Our ref: SSD-10405 MOD 1
EF22/8751

Subject: Atlassian Office and Hotel Development (SSD-10405-Mod-1) – Response to Submissions and DPE Matters

Schedule 1 – Additional information required

GENERAL ARRANGEMENT
PLAN BASEMENT 1

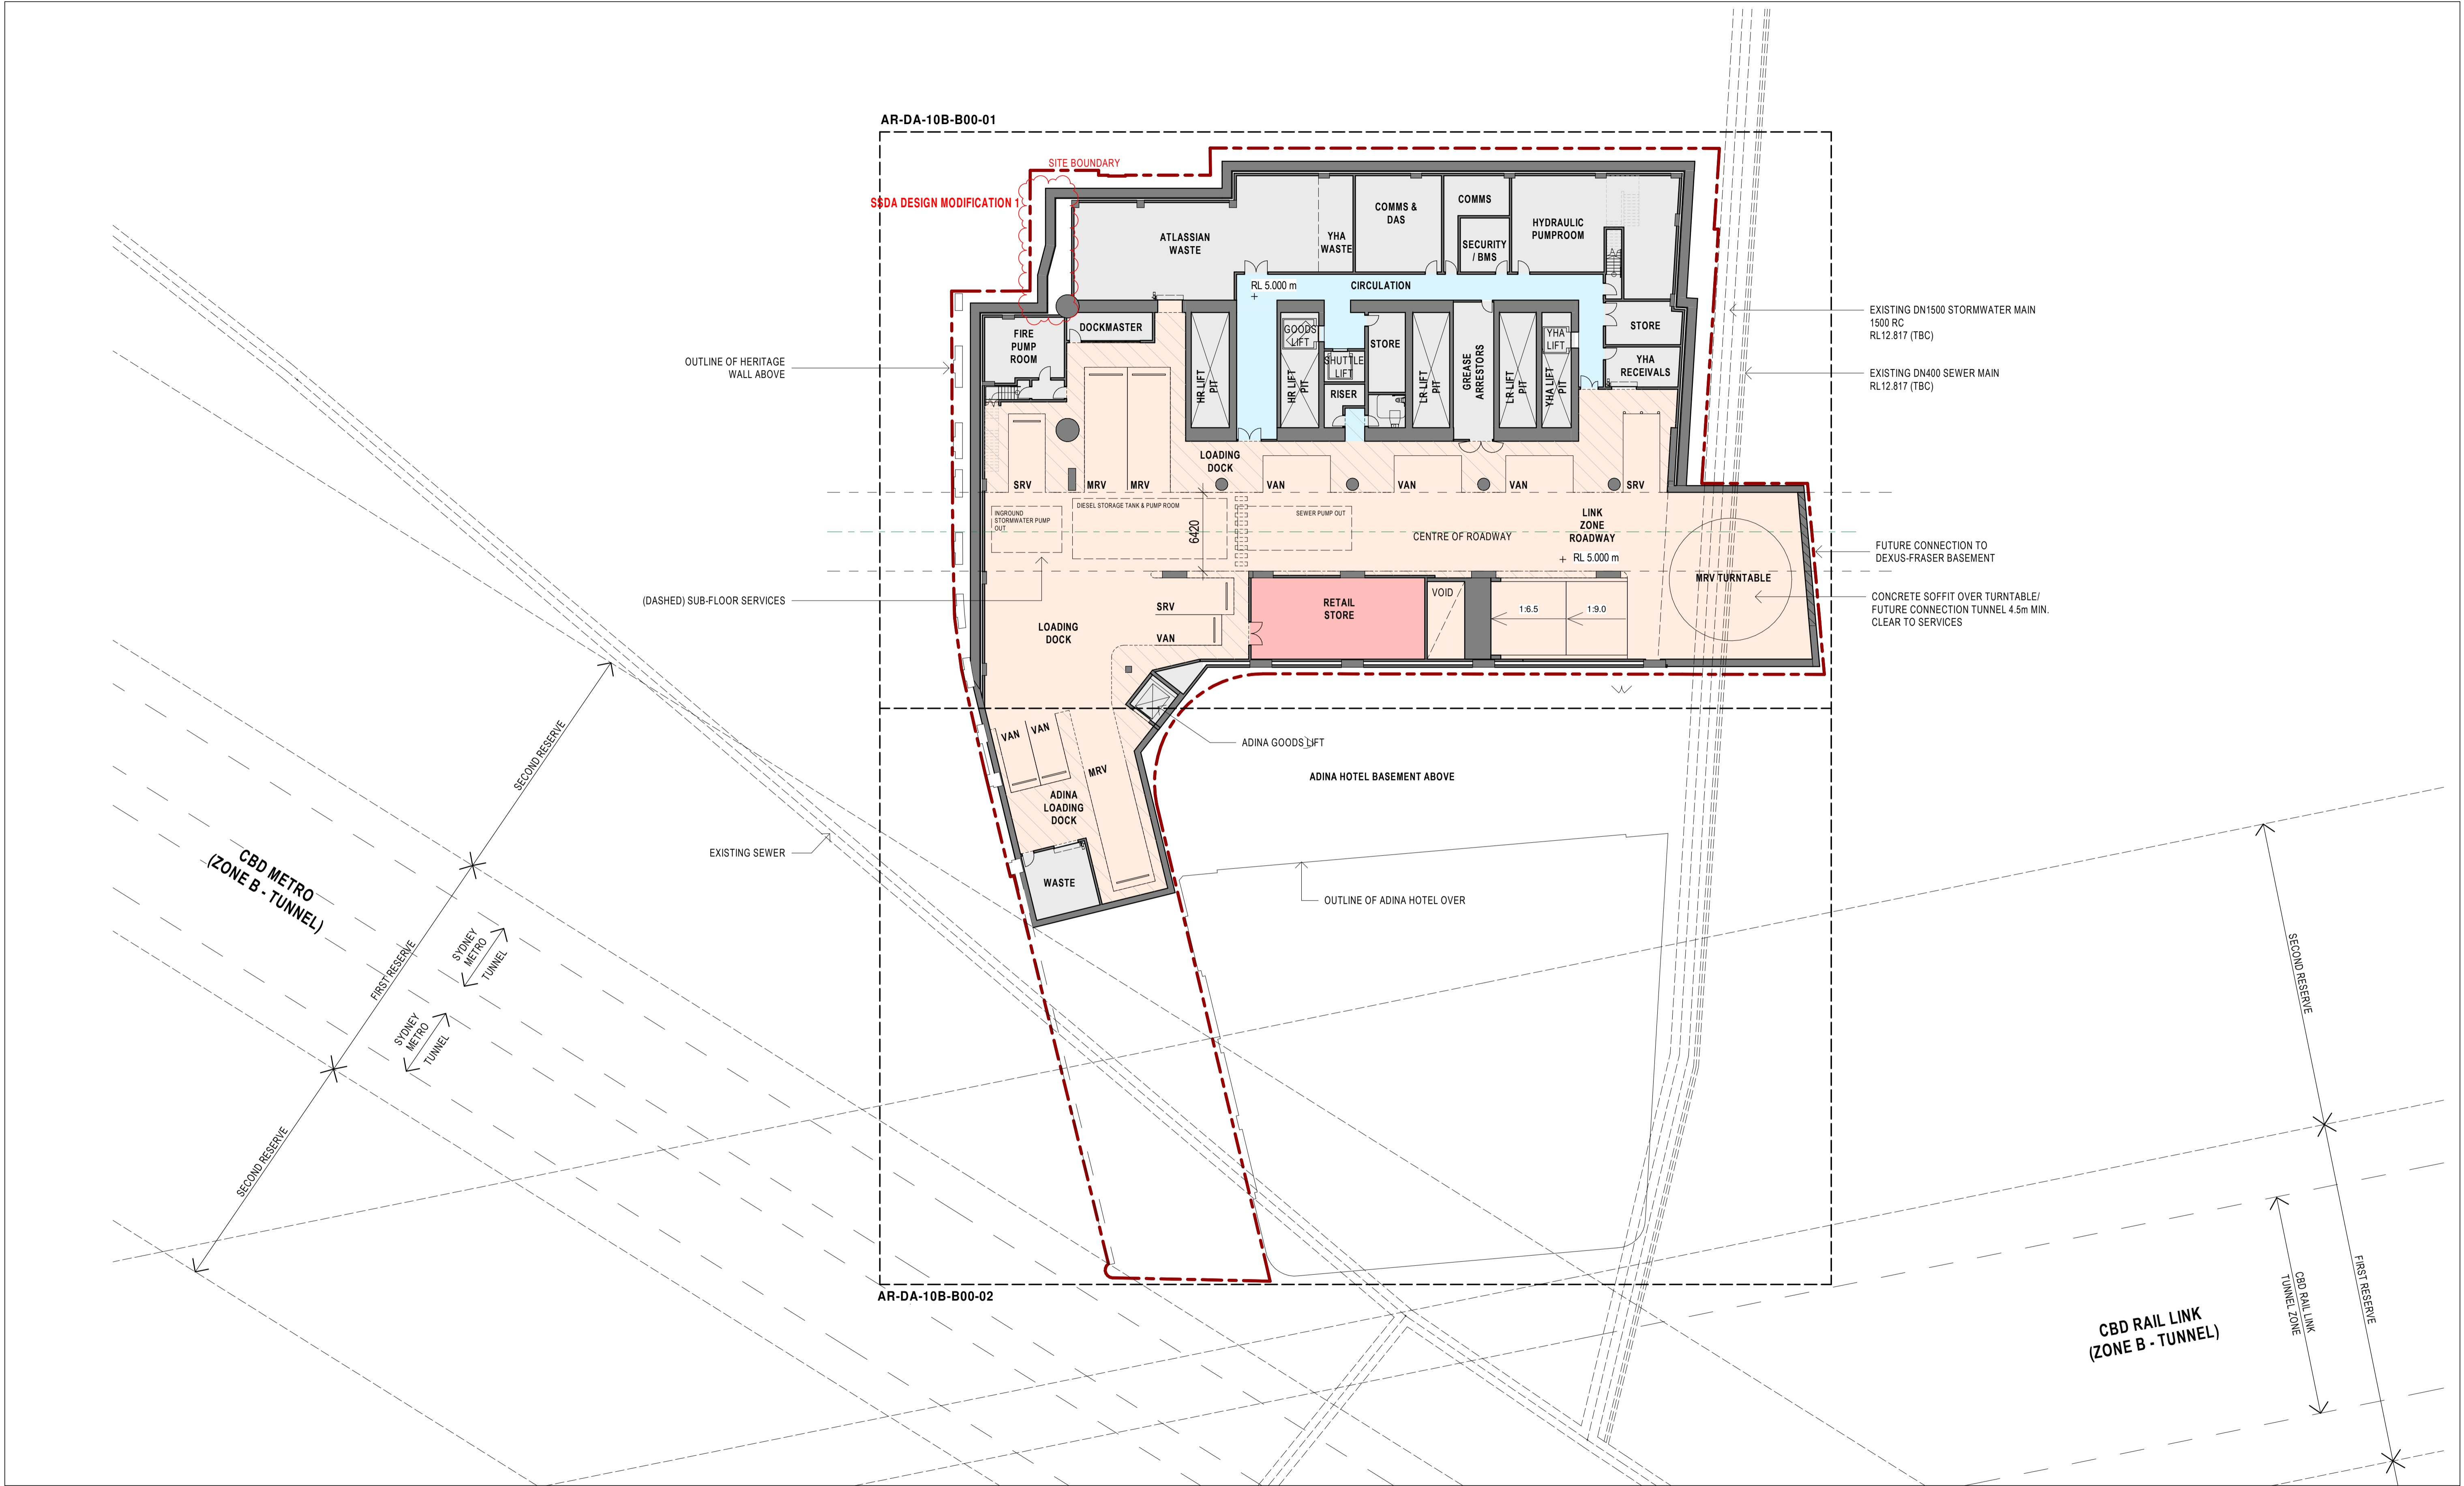
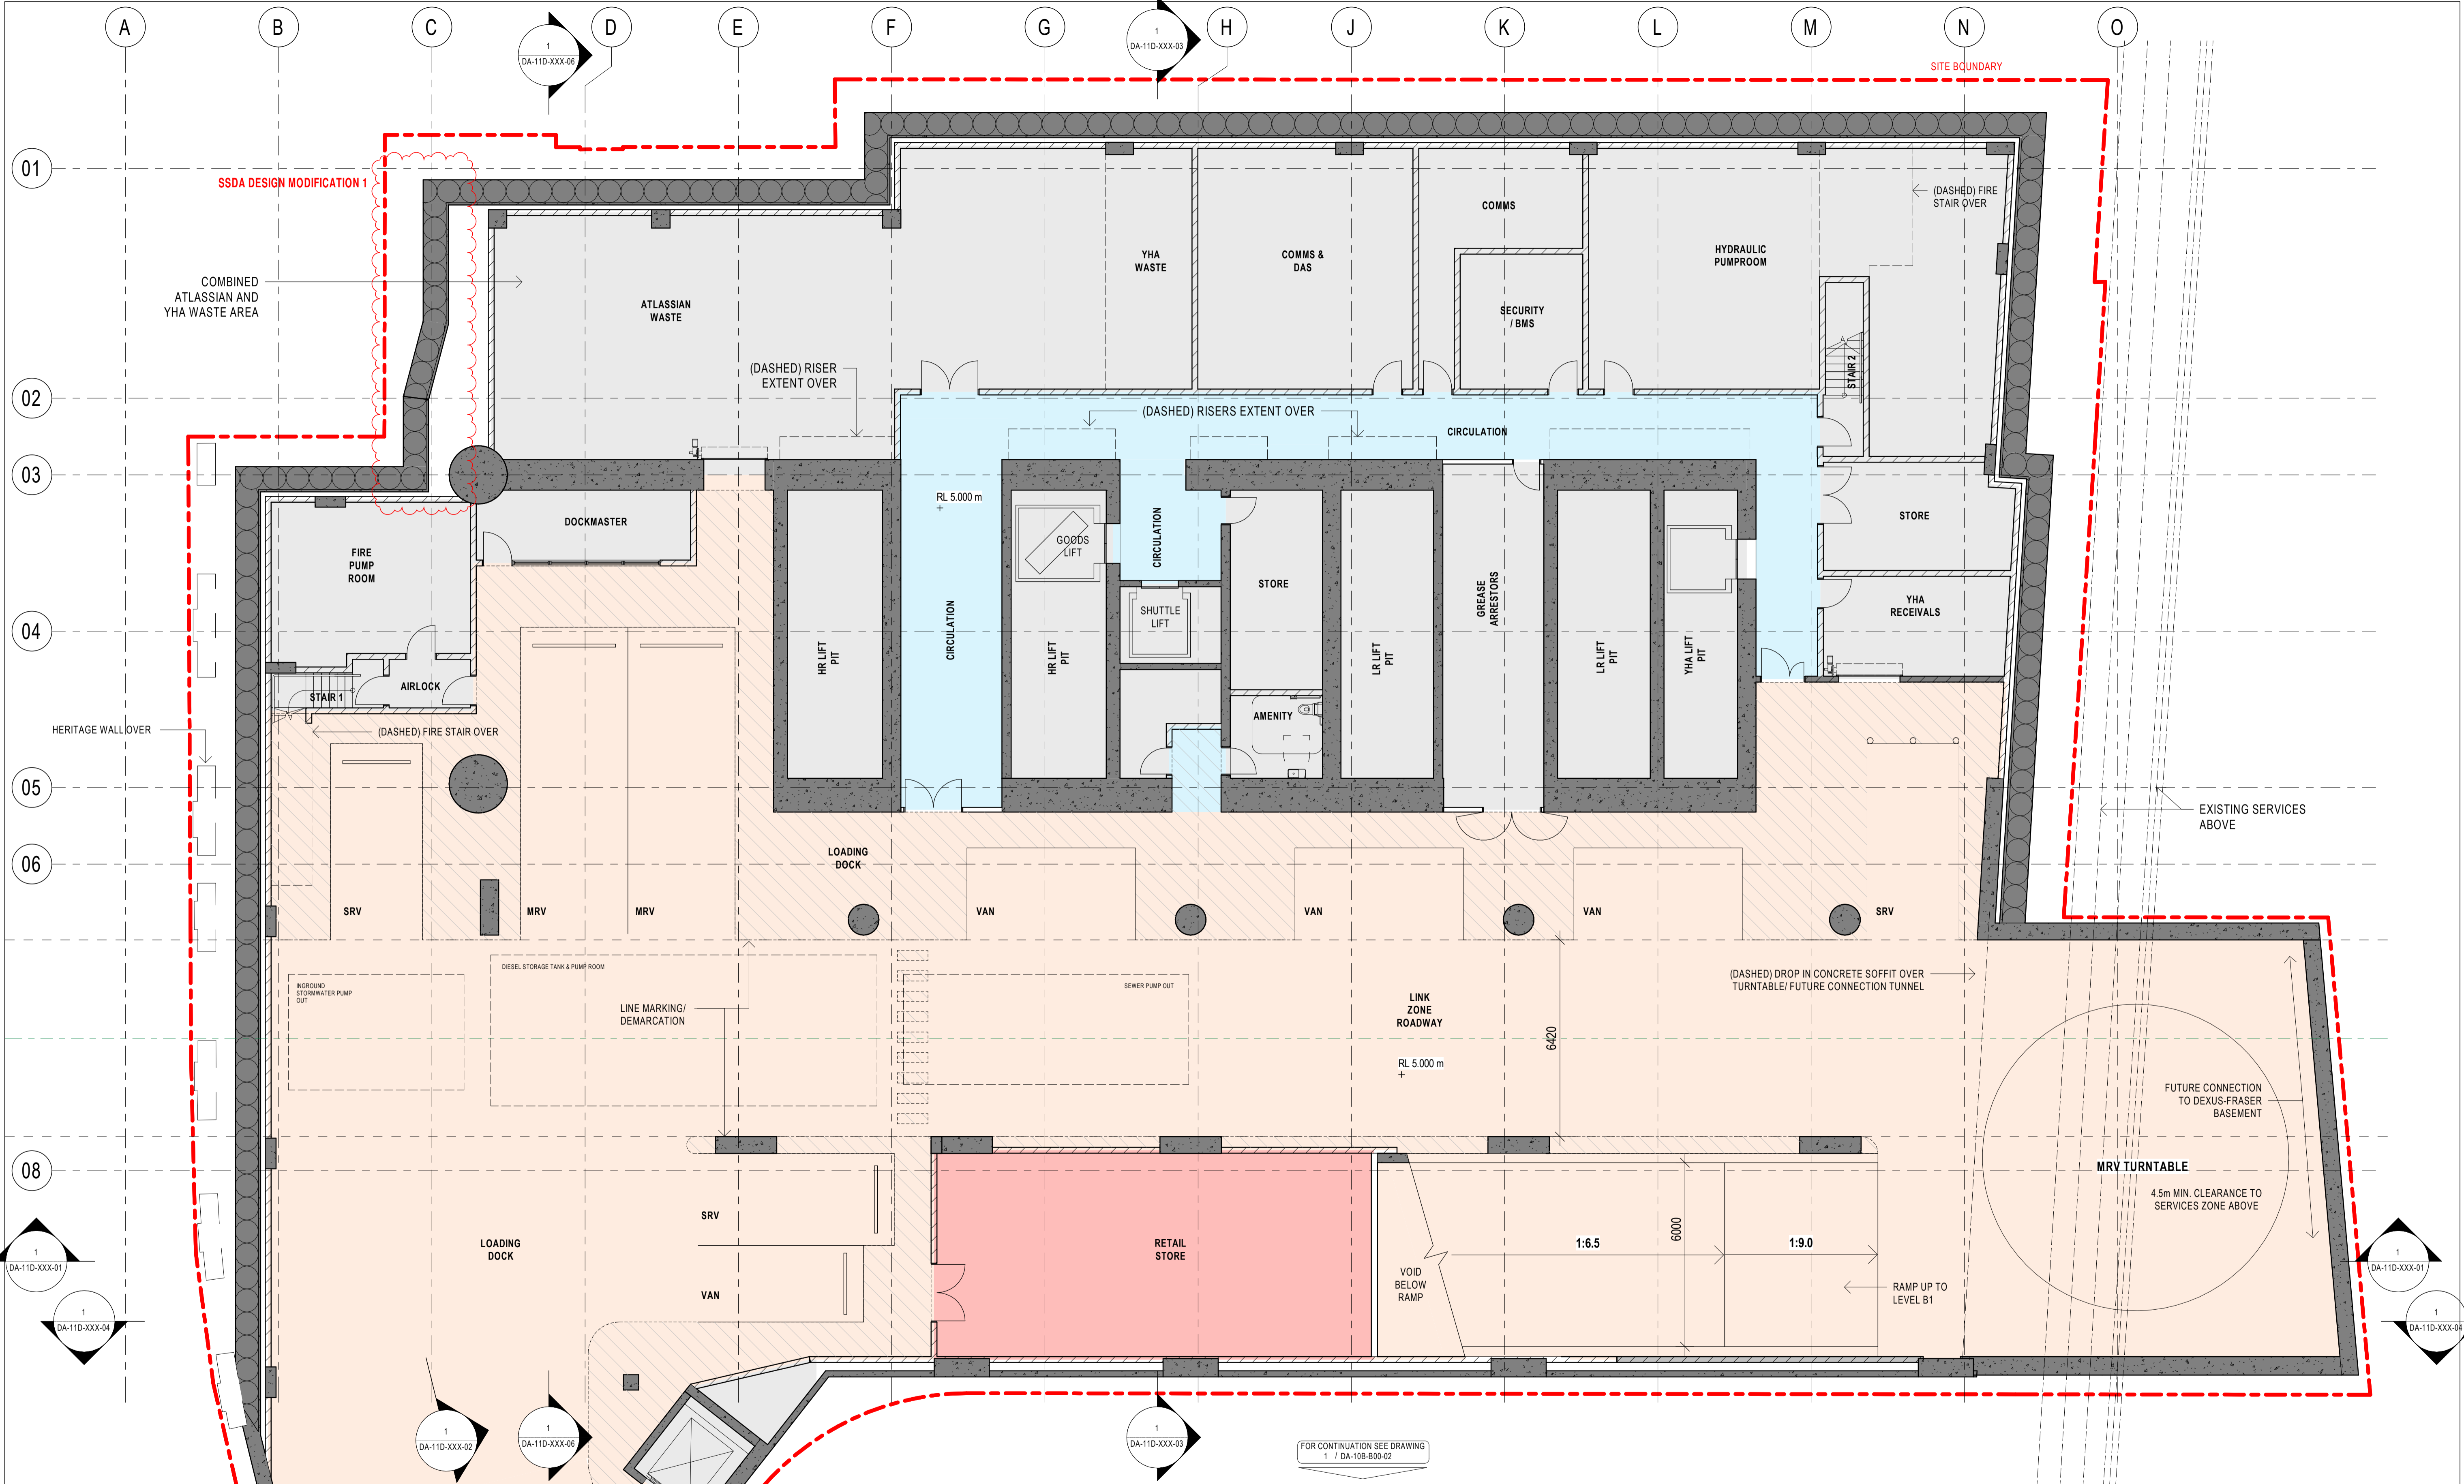
- The Department has identified a number of additional minor changes shown on the architectural plans submitted alongside Modification 1 which were not approved in the plans as part of SSD 10405. The Department has clouded the discrepancies on the architectural plans in Appendix A. Please clarify and provide justification for any additional design changes sought.
